From: Hardie, Simon <Simon.Hardie@lancashire.gov.uk>
Sent: 17 March 2021 17:22
To: John Macholc <John.Macholc@ribblevalley.gov.uk>
Cc: Bloomer, David <David.Bloomer@lancashire.gov.uk>
Subject: RE: 3/2021/0230

We are OK with the principle of the bridge repairs, however we would require a Section 278 agreement for the works to the surfacing of the bridge deck, and the associated footways kerbing bollards etc. there are concerns regarding the proposed pedestrian barriers which can be addressed during the 278 consultation prior to the agreement being signed.

C SECTION THROUGH BRIDGE LOOKING DOWNSIDE
SCALE 1:20

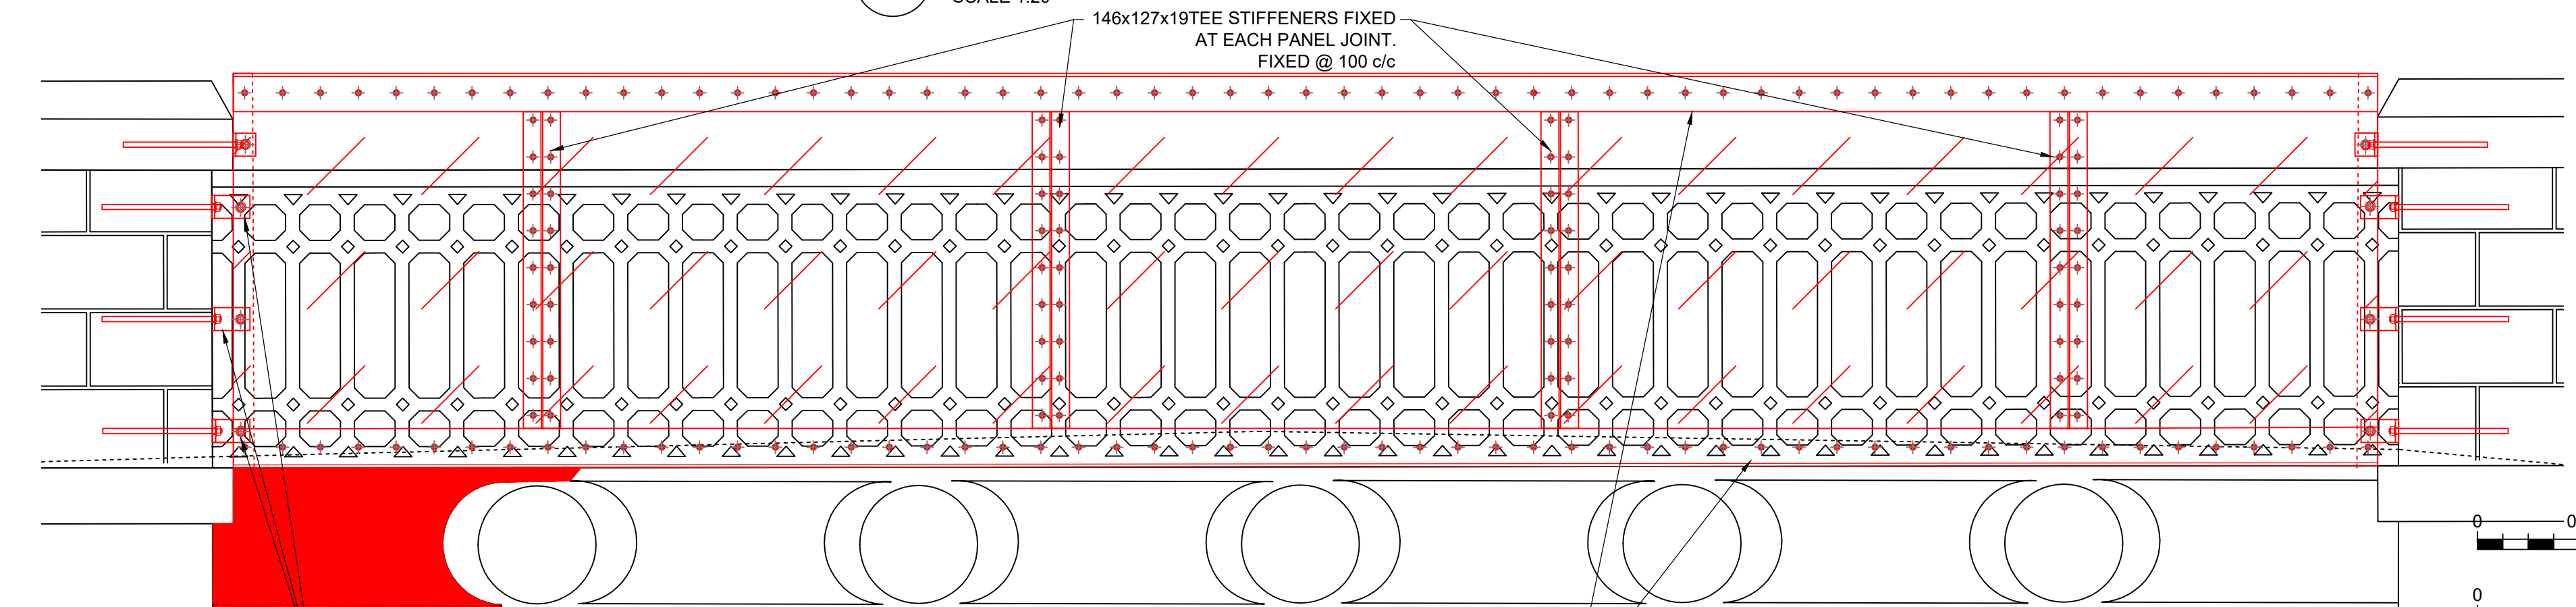
There are a number of questions regarding the narrowing of carriageway, suitability of the approach for larger vehicles including refuse collection by RVBC, diversion route during the in potential road closure, temporary pedestrian crossing to allow access to the station and bus routes on the A666. This is not a comprehensive list of concerns as the full extents and implications of the works is not known.
